Project Name: Land off Staple Street, Hernhill, Kent, ME13 9HY

Document Reference: 65204822-SWE-XX-XX-T-C-0002

## Planning Reference 20/503666/FUL - Discharge of condition 14 under application number 22/505852/SUB.

Drawing Number: **65204882-SWE-ZZ-XX-DR-C-0100**

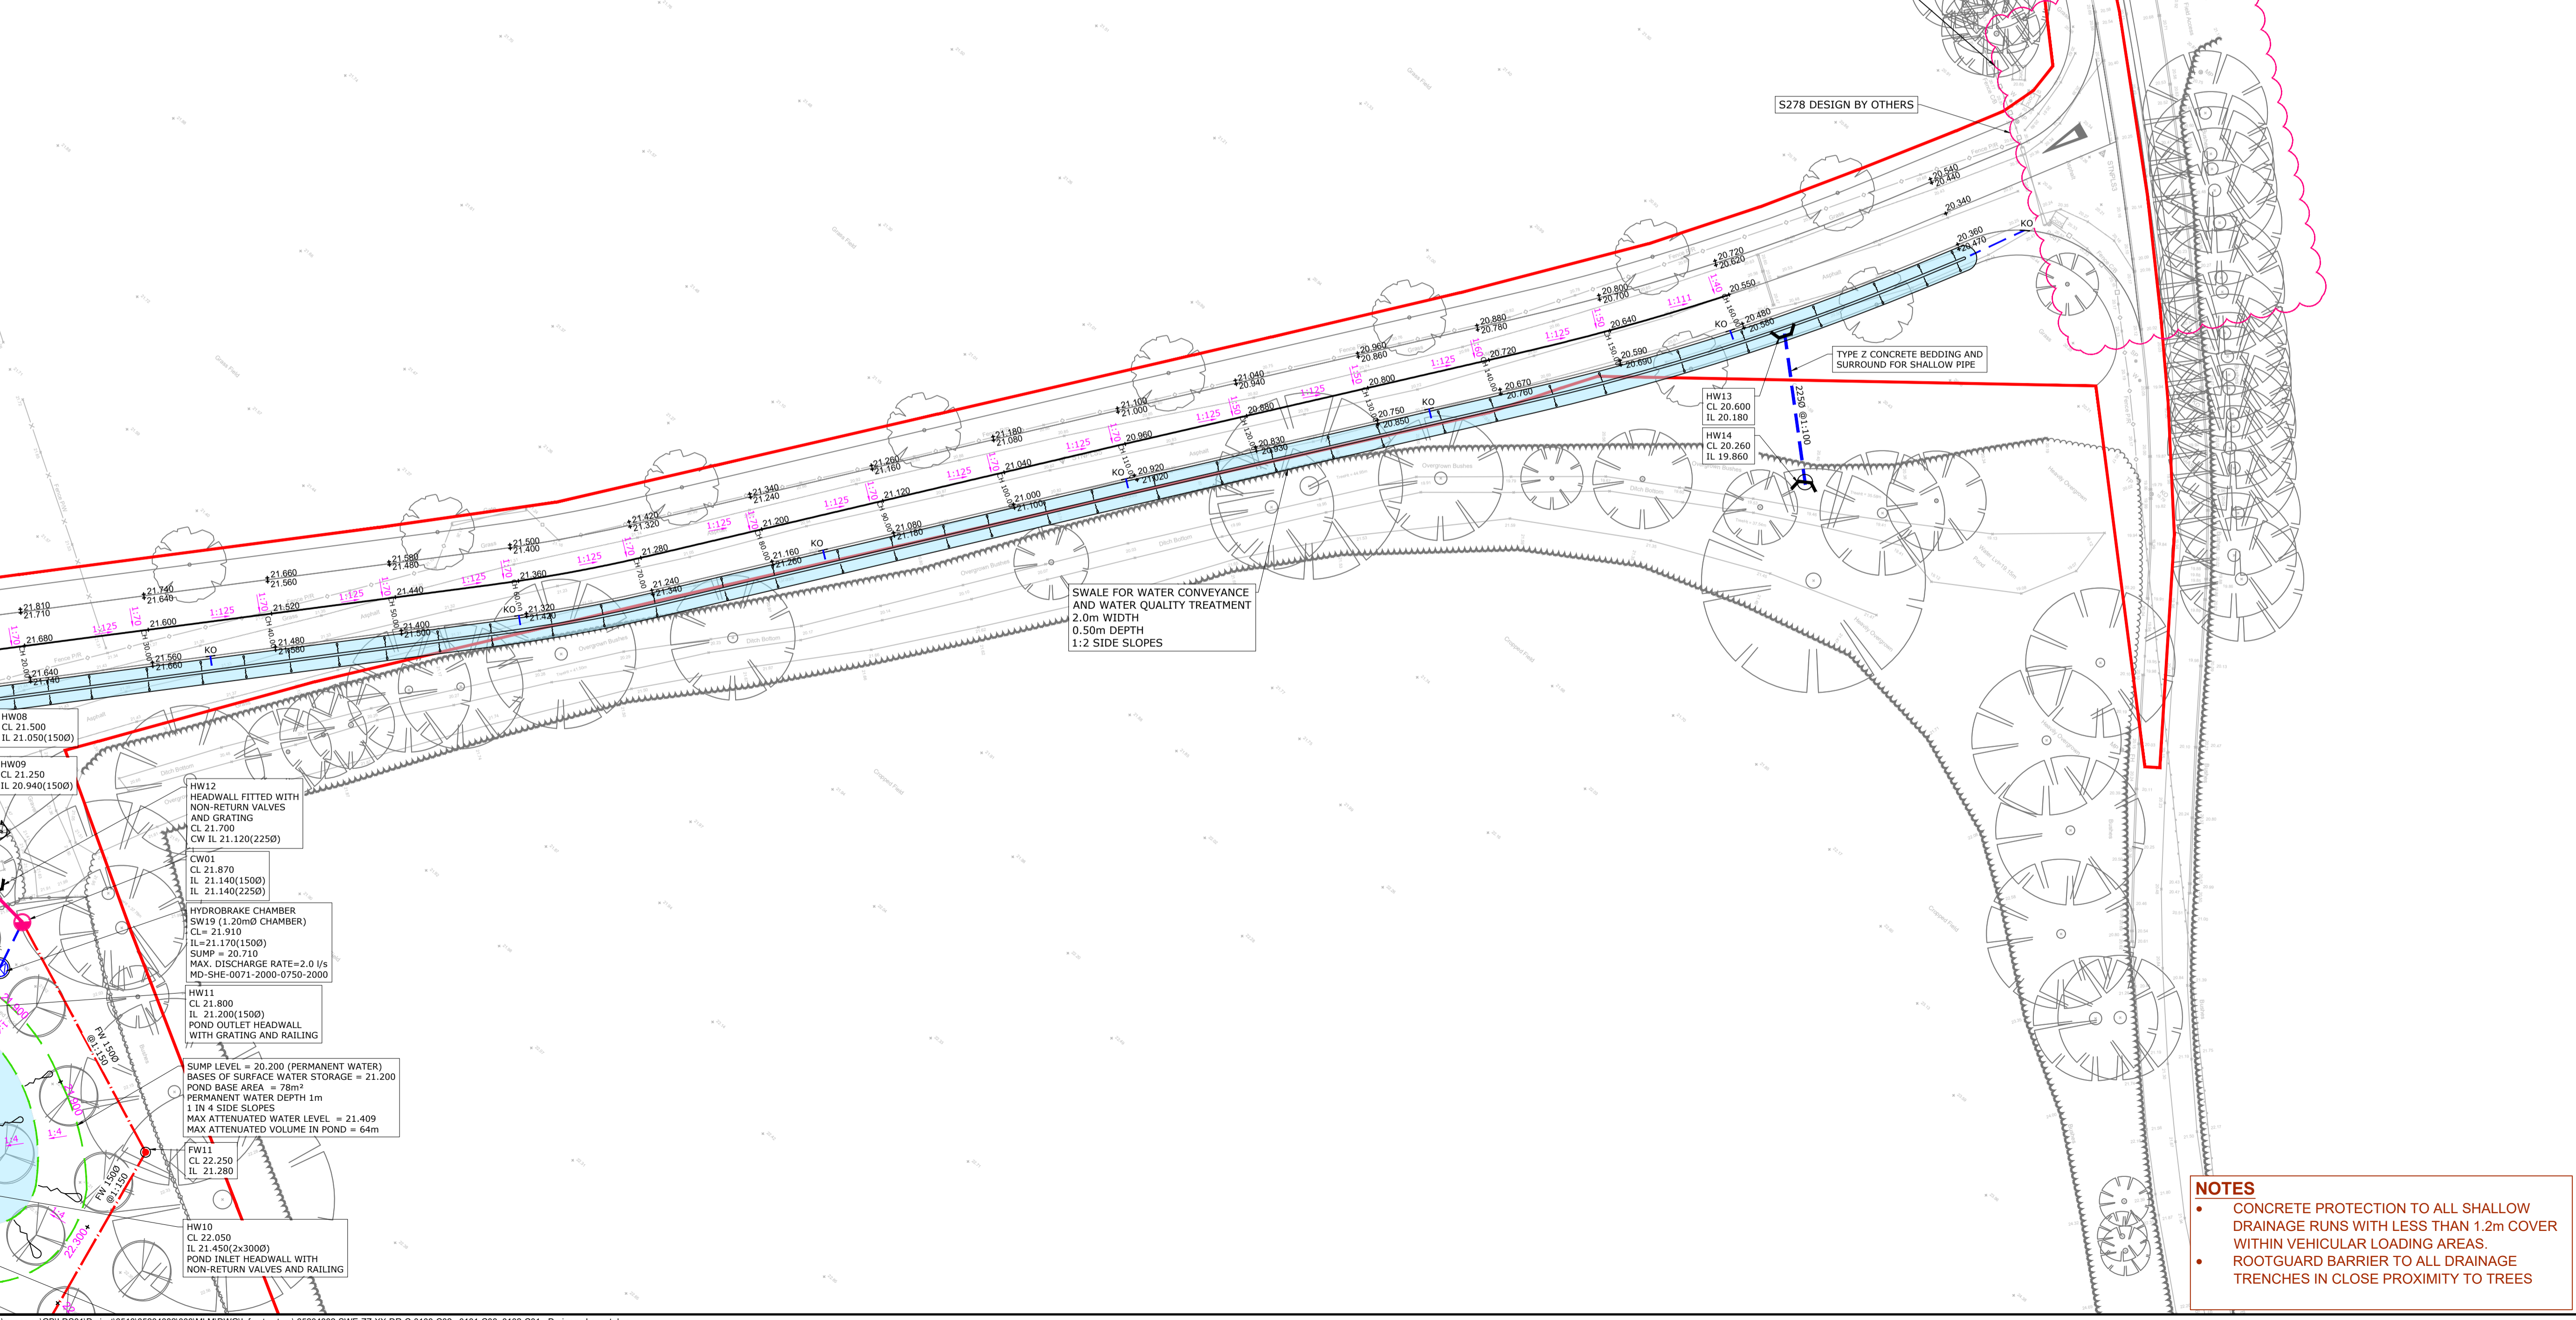
- 1. We note that the discharge rate previously approved on the 15th December 2020 was 2 l/s from the site. Drainage Layout Sheets 1 and 2 (65204882-SWE-ZZ-XX-DR-C-0100 and 65204882-SWE-ZZ-XX-DR-C-0101) now provided, appear to show three further points of unrestricted discharge into the ditch. We would expect discharge from the whole site to be restricted to 2 l/s as previously approved unless it can be shown that discharge rates from the site are not exceeding greenfield rates for their respective storm events or QBAR.*

The previous surface water drainage from the access road allowed surface water runoff to be directed across the verge and into the existing ditch. The new layout will mimic the previous drainage by directing surface water to a swale before discharging to the ditch. The IH124 calculation in Appendix A provides the greenfield runoff rates for the site in the table below. The table shows that the proposed surface water discharge rates are not exceeding the greenfield runoff rates for this site in accordance with Chapter 7 of the Kent design guide *Making it happen – sustainability (drainage systems)*.
